Rezoning Petition Review

From: Jay Wilson

Date of Review: August 30, 2021

Rezoning Petition #: 21-089

SHEET TITLE:  
**CONDITIONAL REZONING: CONCEPTUAL SITE PLAN**

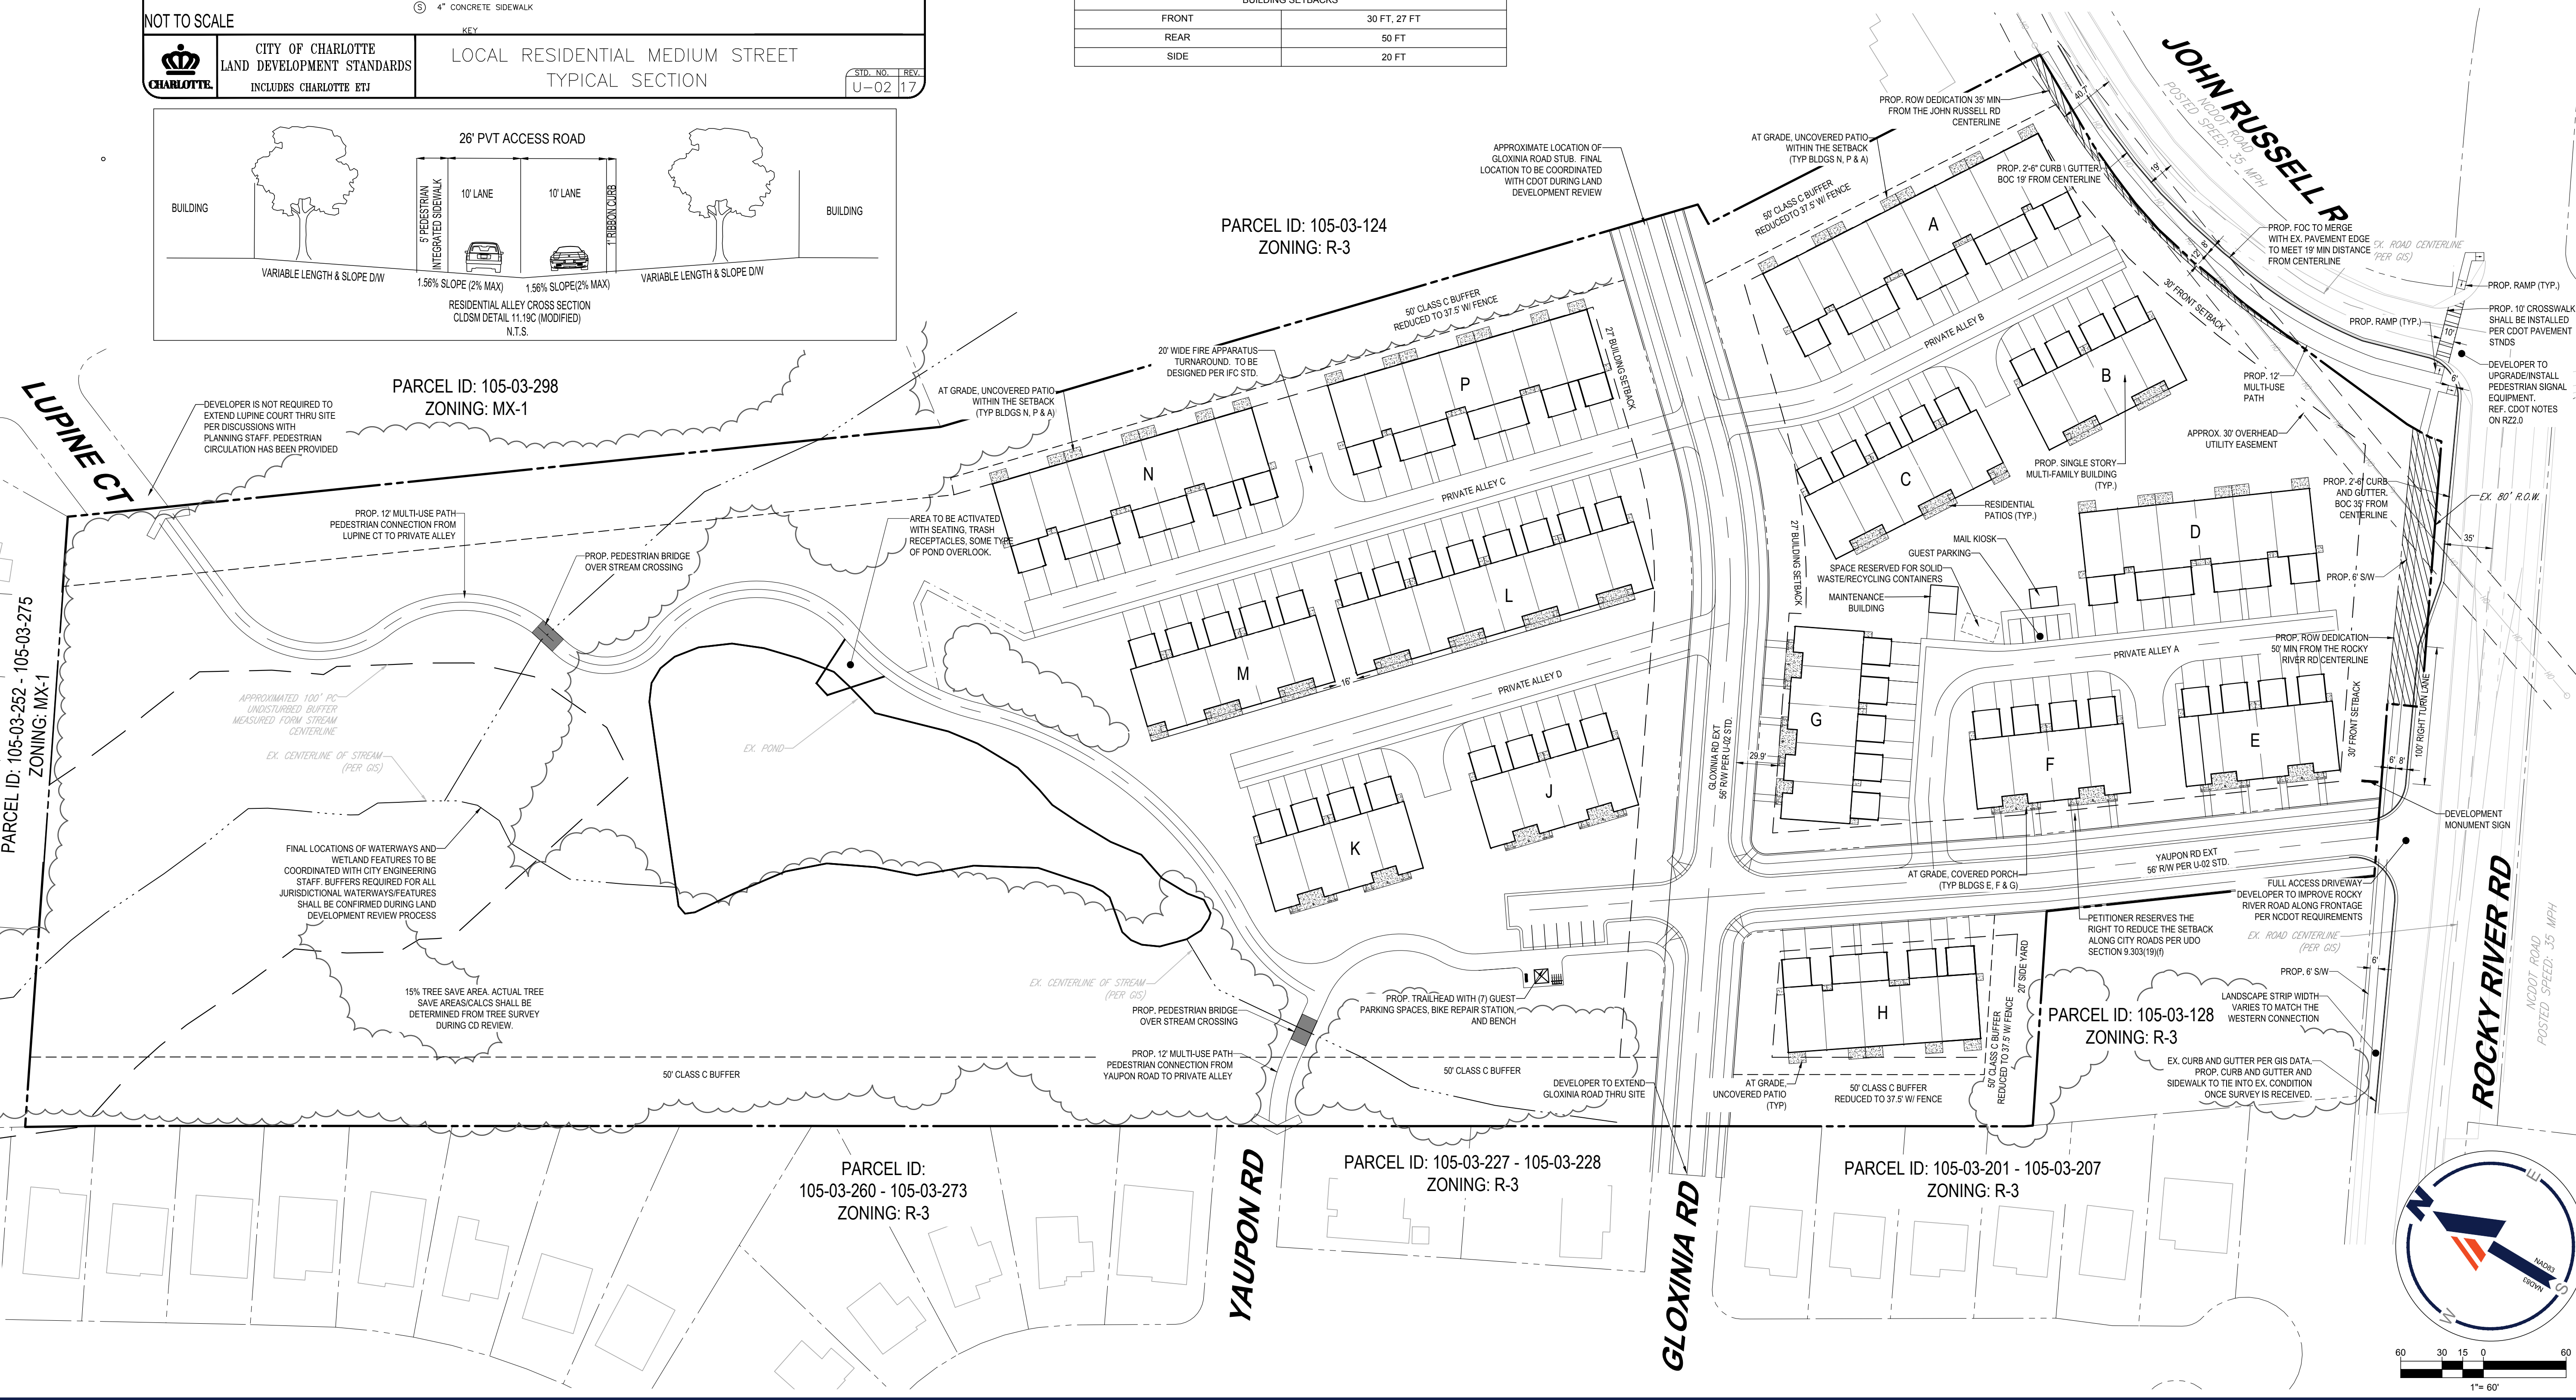
Drainage/Stormwater Management: Stream/wetland survey required prior to approval of civil site plan to ensure accurate delineation of top-of-bank/stream buffers/creek path and identification of any protected wetlands that may be on the site.
